Technical Note

Client	Warrior Developments
Project	High Street, Goldthorpe
TPS Reference	P1902
Date Prepared	March 2022
Prepared By	JM
Checked By	CG

- 1.1 TPS Transport Consultants Ltd (TPS) has been appointed by Warrior Developments to prepare a Highways Technical Note in support of a planning application for the redevelopment of the former Goldthorpe Primary School site, to the immediate south of Doncaster Road, in Goldthorpe.
- 1.2 The site is currently subject to a planning application (ref: 2022/0056), which is pending a decision.
- 1.3 This Technical Note has been prepared to address comments provided by Barnsley Metropolitan Borough Council (BMBC) dated February 2022

Client:	Project:	Former Goldthorpe Primary School	Title:	2021 Base + Committed Development		Number:		Revision:	Date	Nov-21	Checked	JM
									Design	CG	Approved	GS

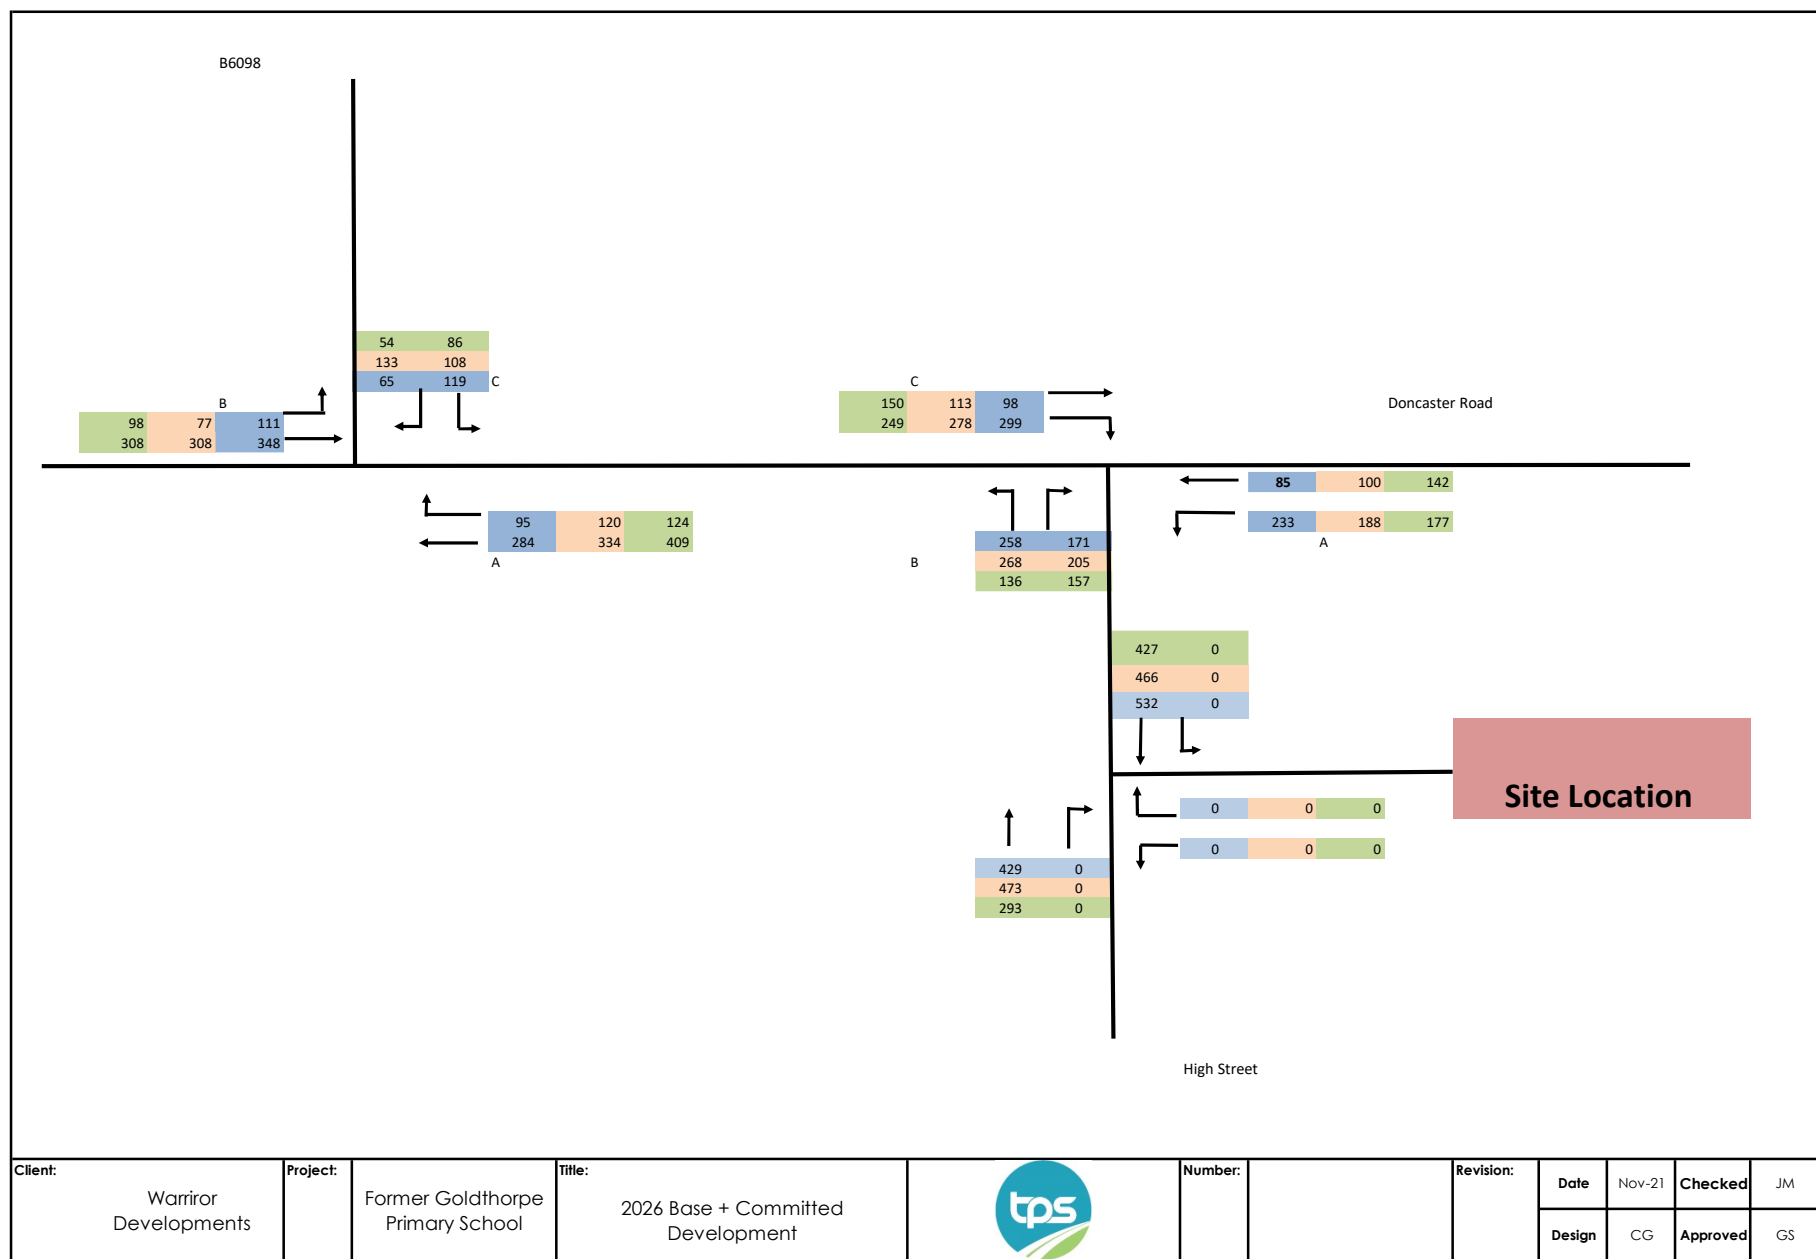
- *For the assessment of the Barnsley Road/Doncaster Road/High Street signalised junction the committed development flows need to include the residential site off East Street (2021/1171) as well as the Kingsmark Way residential development. This application and app.no. 2021/1171 are both current applications that are yet to be determined and I am aware that the Transport Assessments for both proposed developments have been produced by the same Transport Consultants. I would therefore like to see the modelling of the High Street signalised junction in each of the respective TA's to have the same flows and therefore identical results. Also, our Traffic Signals department has stated a requirement for the signalised junction to be modelled using sat flows of 1600 PCU's. Although this is lower than the figure that would perhaps ordinarily be used elsewhere, there is significant evidence that shows that sat flows are lower than average in Barnsley.*

3.4 As requested by BMBC, trip generation for the following two developments have been included as committed development flows, for the operational assessment carried out at the High Street / Doncaster Road junction:

- East Street (2021/1171); and
- Kingsmark Way (2018/0103).

3.5 Traffic Flow diagrams can be found at **Appendix B**.
